**Consultation Response from KC,
Highways Development Management**

2025/90527 Land adj, 67, Elm Tree Close, Norristhorpe, Liversedge, WF15 7BU

**Change of use of land to domestic garden, formation of access and hard surfacing and
erection of 2.0m high fencing, greenhouse and gazebo**

CLIENT:	MR J KAYE
PROJECT:	LAND AT LODGE LANE LIVERSEDGE WF15 7FG
DRAWING TITLE:	AS PROPOSED
PROJECT REF:	2025-060
DRAWING NO:	200
REVISION:	-
SCALE:	AS SHOWN @ A1
DATE:	FEB 2025

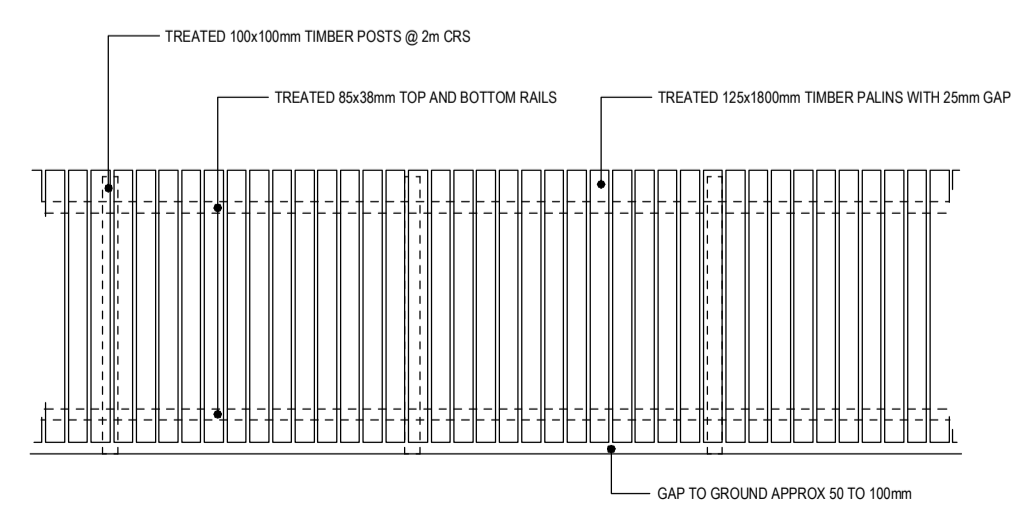
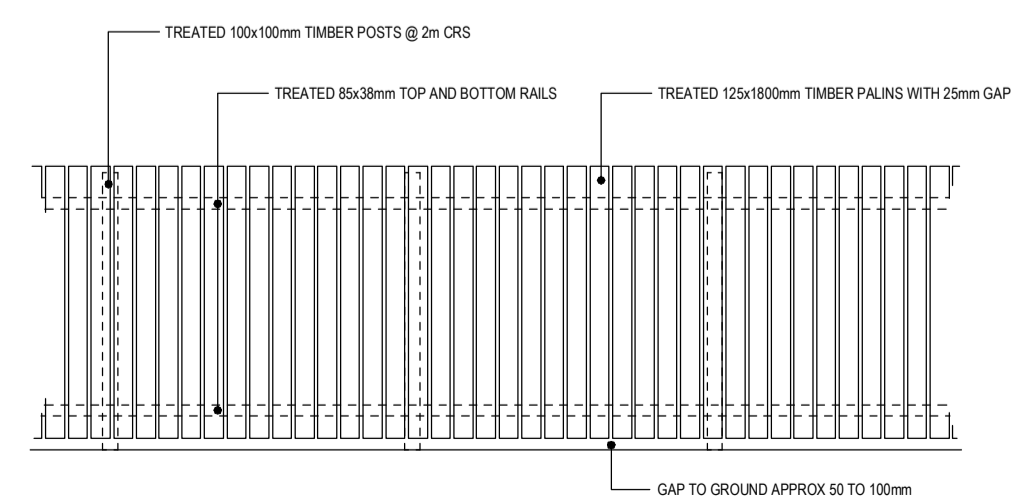
The 2.0m high fence to the frontage will obstruct visibility for vehicles using the proposed access onto Lodge Lane.

The fence will also obstruct visibility for pedestrians exiting the public footpath adjacent to the boundary (SPE/145/20) and the Elm Tree Close footway where it meets Lodge Lane.

For these reasons H D M would recommend that the fence is reduced in height to no more than 0.9m above the level of the adjacent highway and that suitable visibility and pedestrian/vehicle intervisibility is shown to be provided.

HDM would however disagree with all the comments regarding visibility from the public footpath adjacent to the boundary (SPE/145/20) and the Elm Tree Close footway where it meets Lodge Lane.

Pedestrians should not have to look through fencing to see on-coming traffic however slow.

HDM would therefore recommend that the fencing is set back 1.0m to allow suitable pedestrian/vehicle inter-visibility from both footways onto Lodge Lane.
